From: Simon Davis
Sent: 02 August 2022 17:20
To: Chris Pope 
Subject: RE: AW/104/22/PL 8 Gossamer Lane, Aldwick

Drawing
Location, Site, Floor Plans

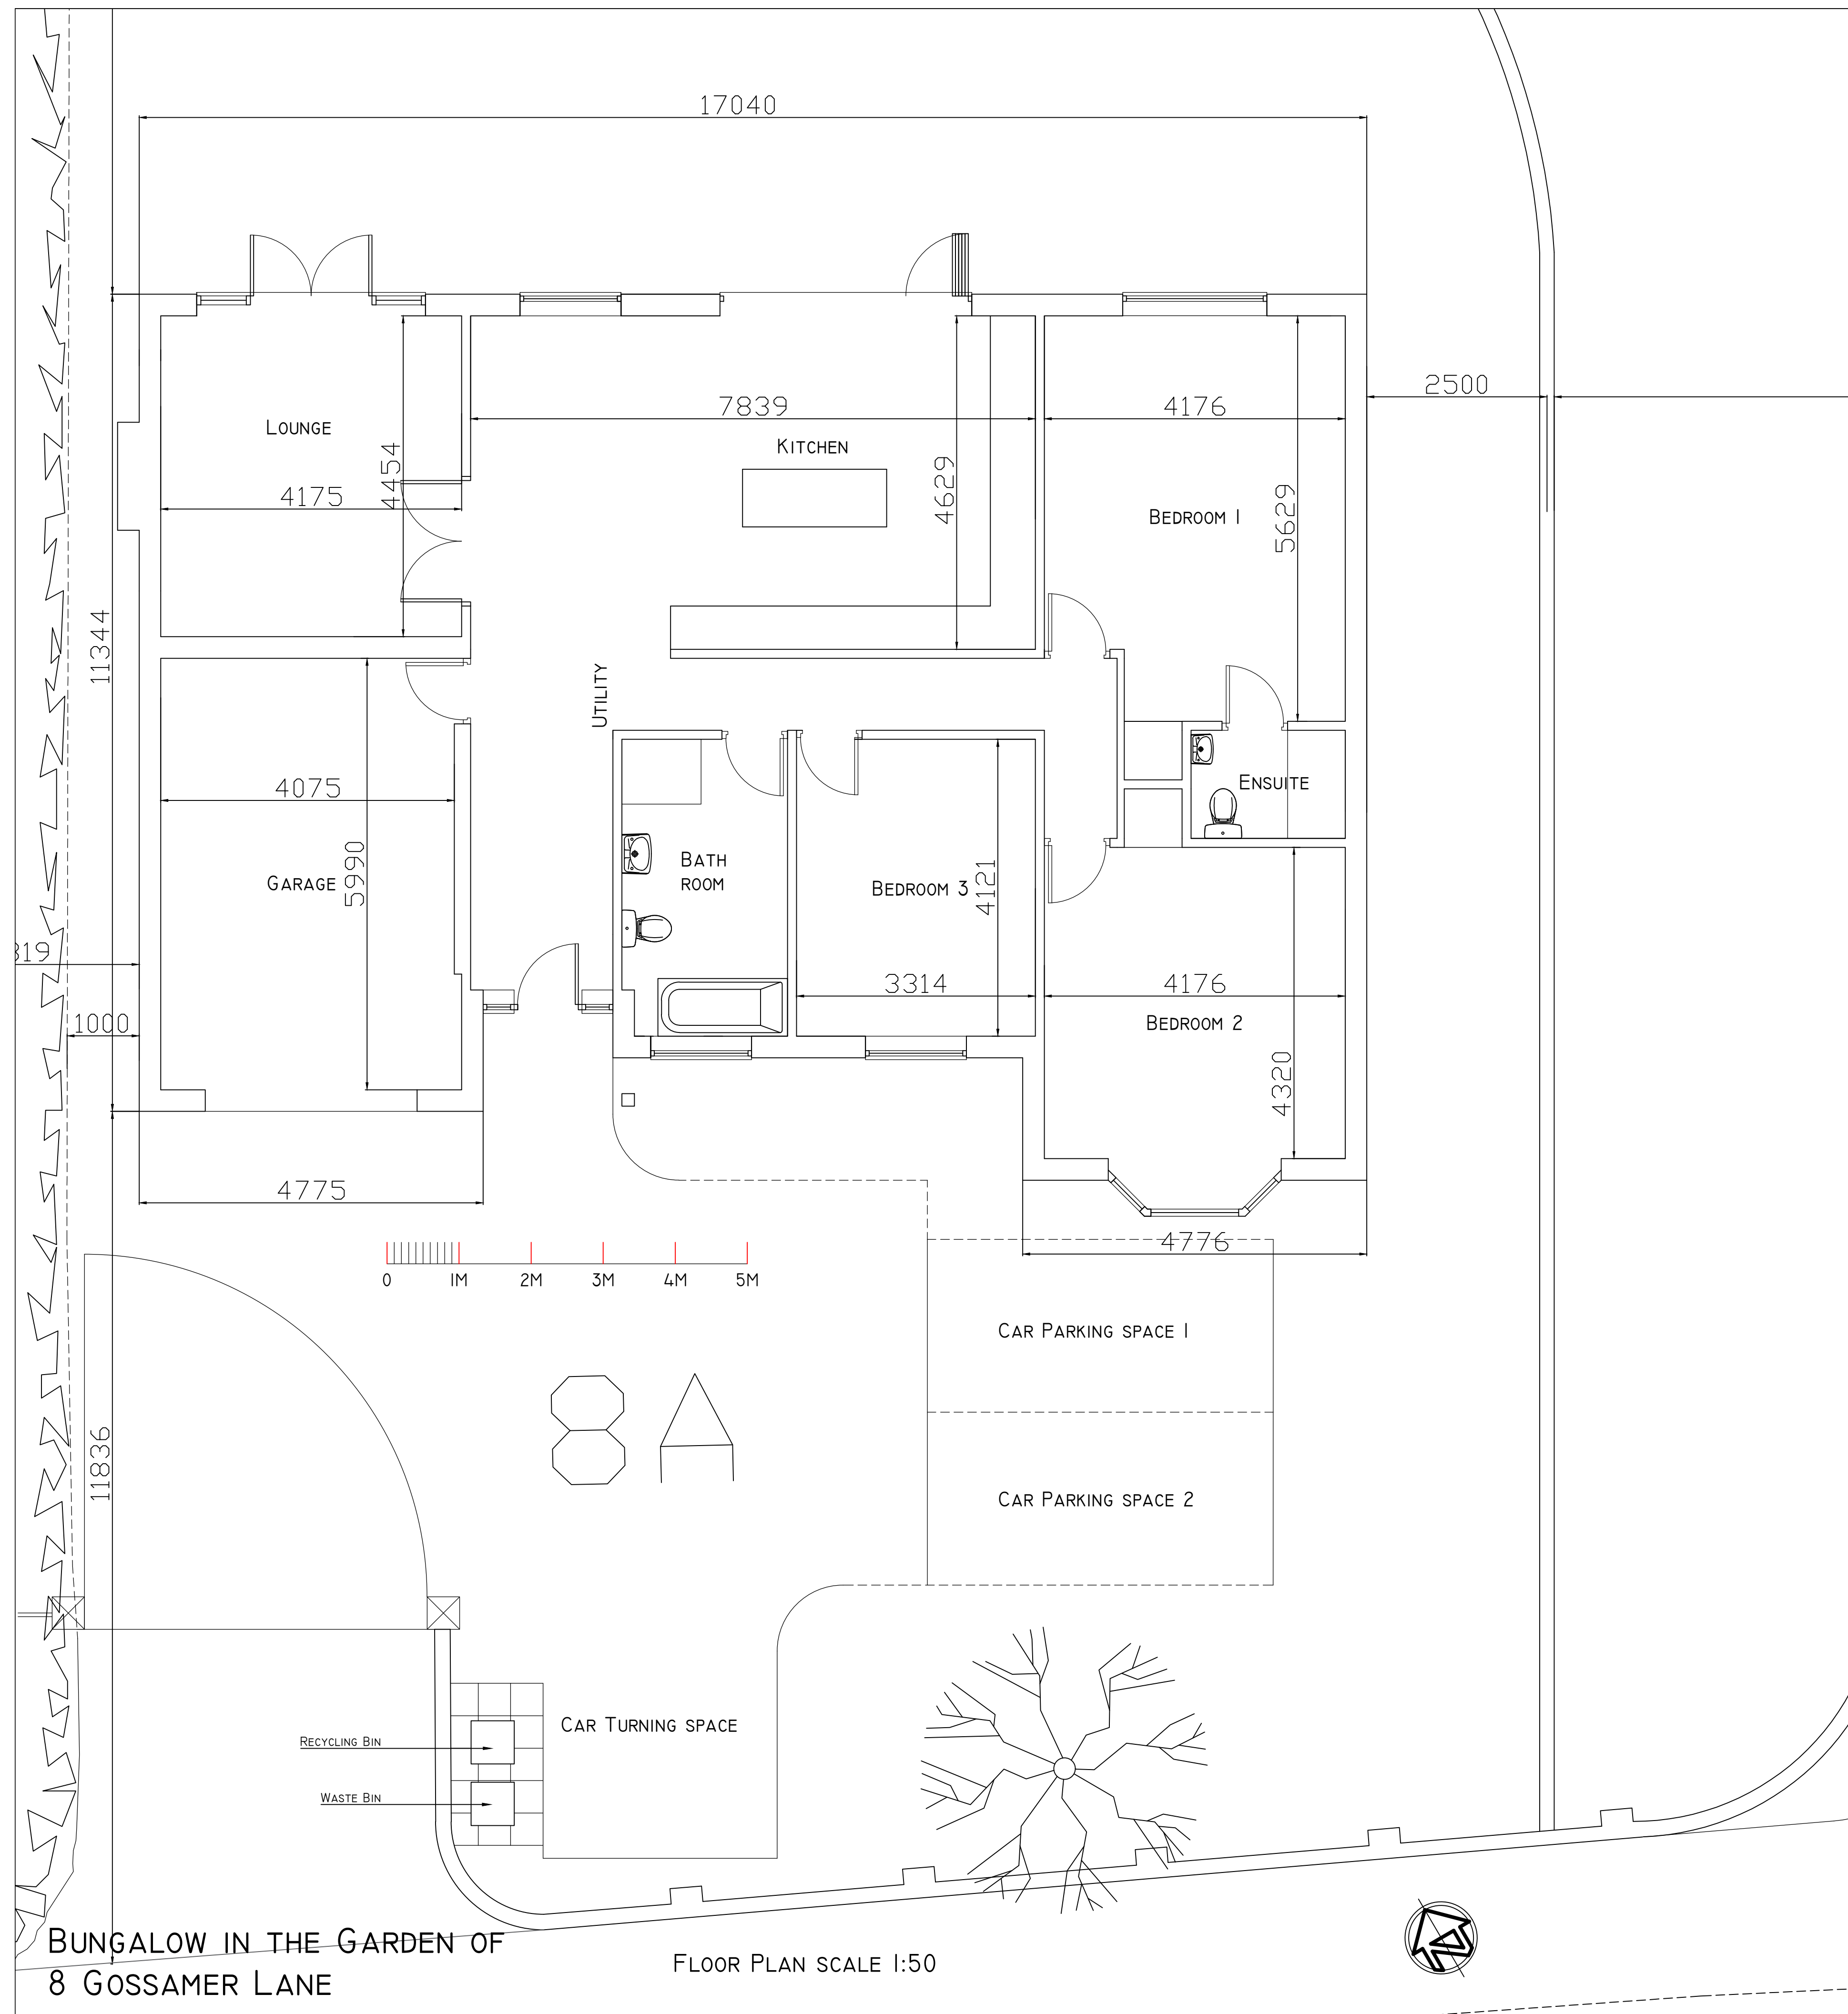
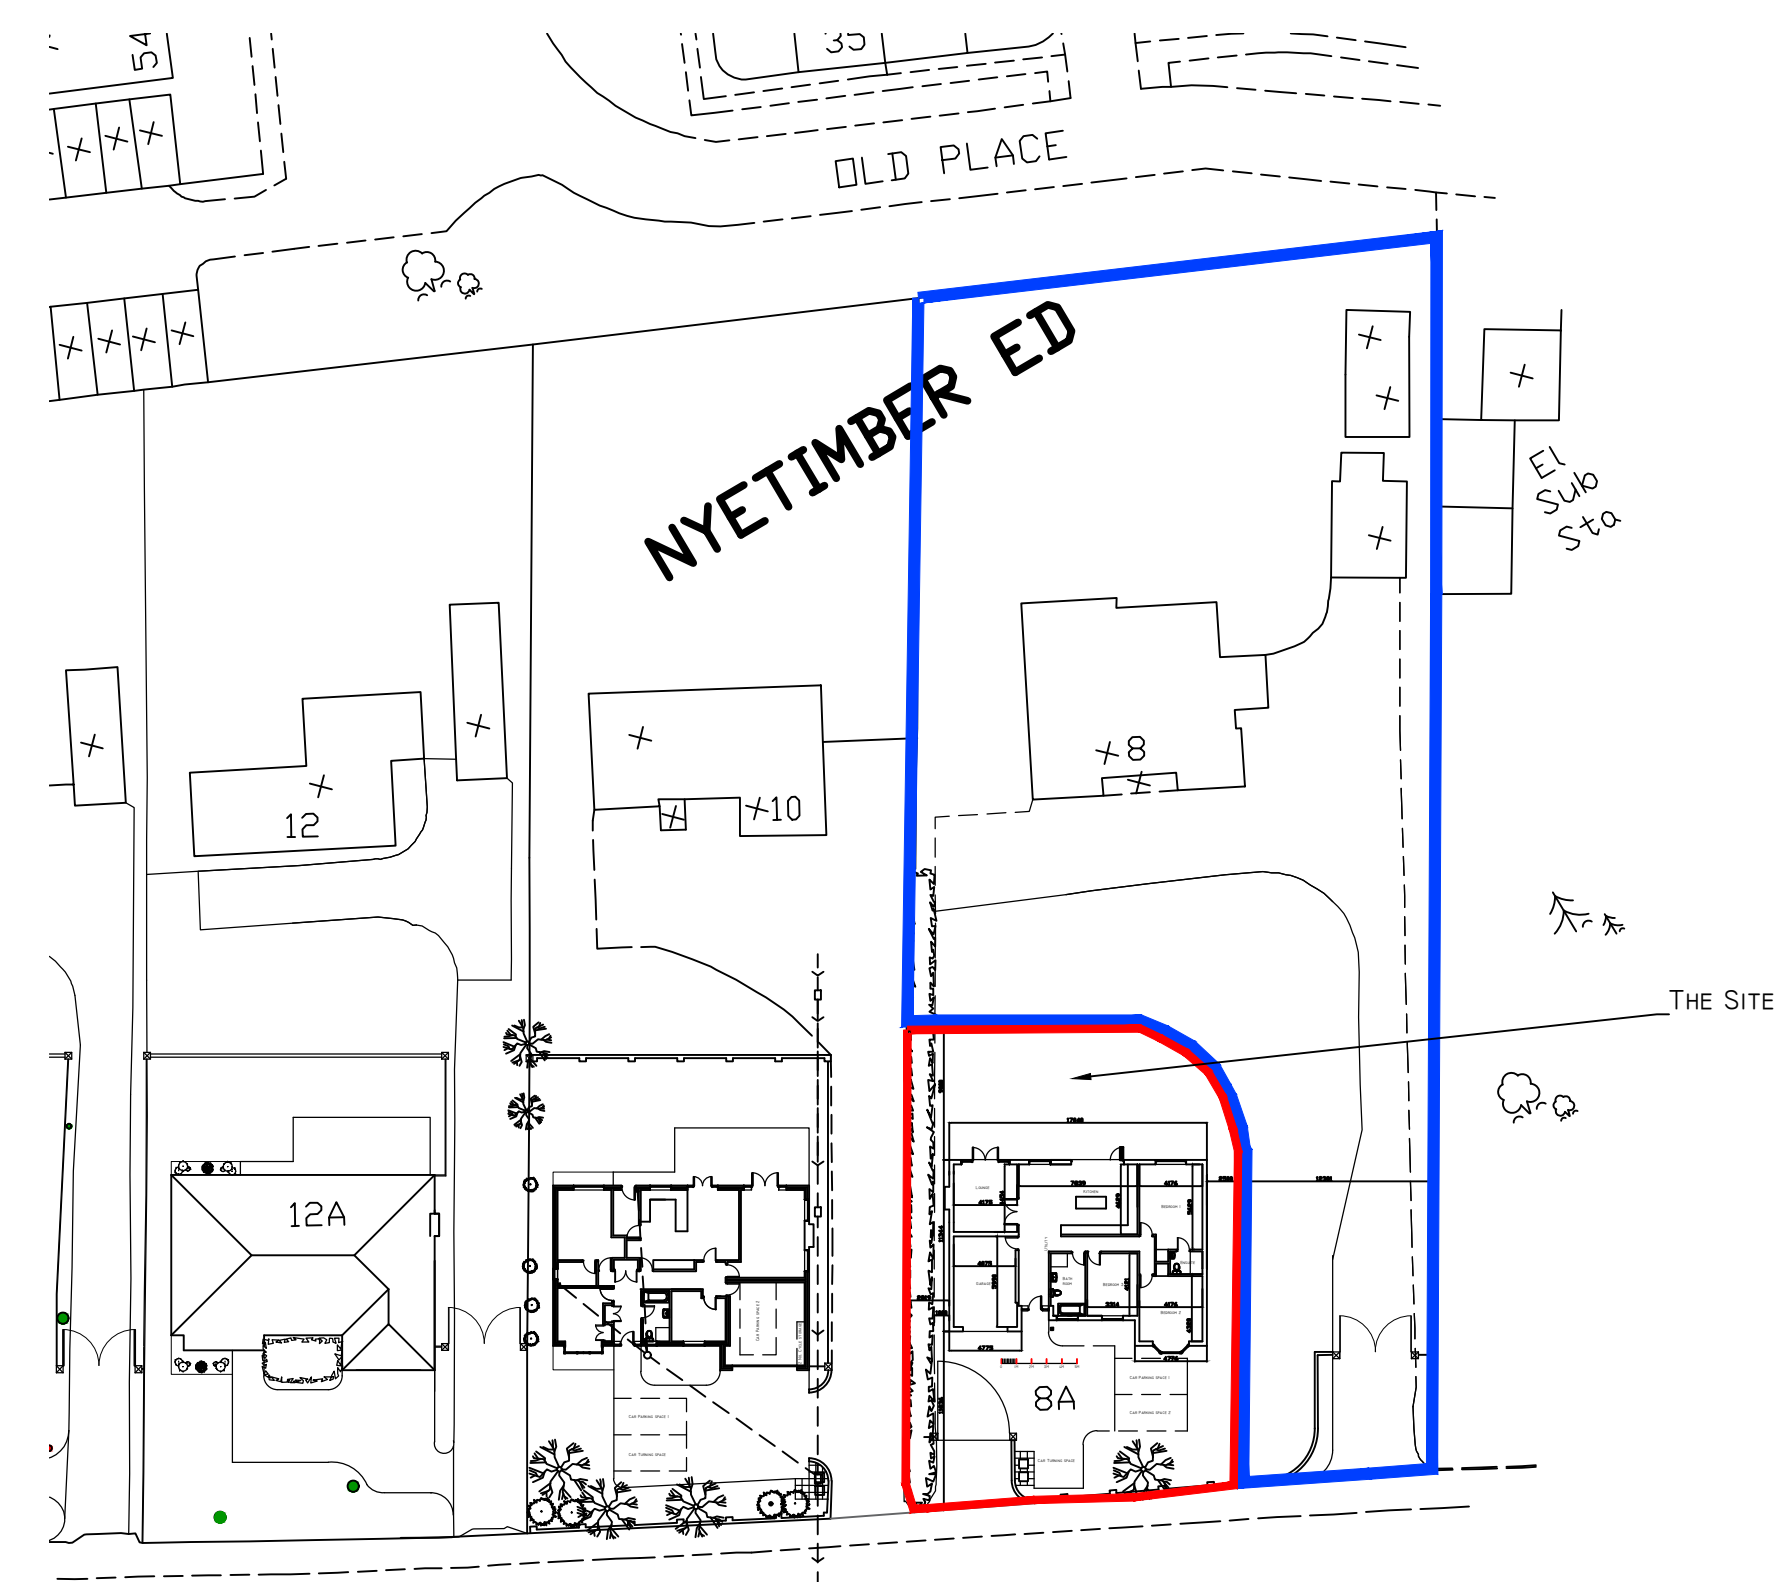
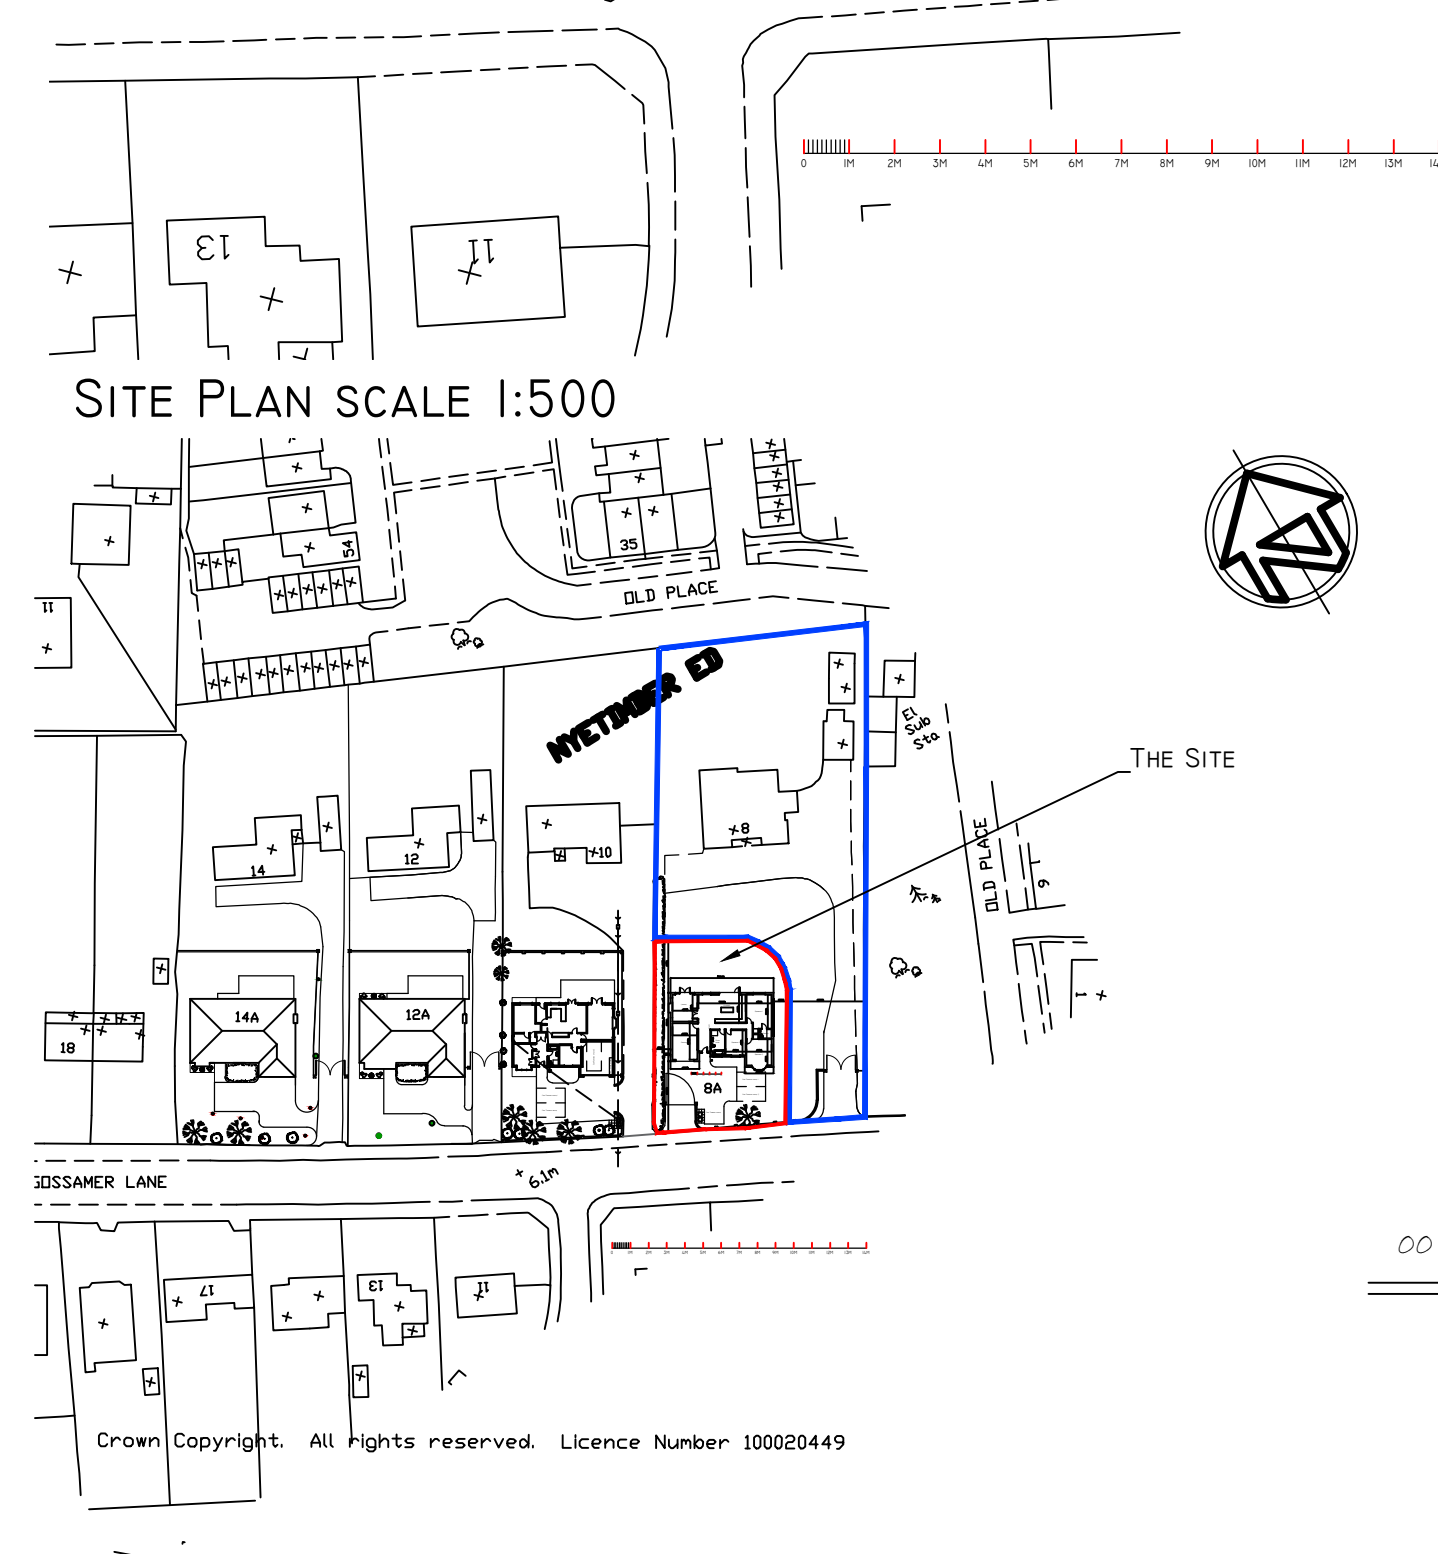
Our Conservation Officer has stated the following: *"It would appear that the existing (right hand) gate pier to the eastern access point, matches one found within the (Grade II Listed) Old Place development walling. It is recommended that this be retained in position as part of the alterations to the access points. Likewise, the remainder of the existing walling, whilst clearly modern, makes a positive contribution to the street-scene, and every attempt should be made for any alterations and new work to match the existing."*

I note that the gate pier falls within the blue not the red edge but can you confirm that no changes are proposed to the existing eastern access so that the pier can remain as is. I believe this to be the case but just need confirmation.

I can confirm that the existing Eastern pillar of the right hand gate (when viewed from Gossamer Lane) will not be changed or moved in any way. The left hand pillar will be widened by approx 1m and will reuse the original material so as to match the current gatepost as far as possible. The reason for the widening is to improve the visibility and access into the drive.
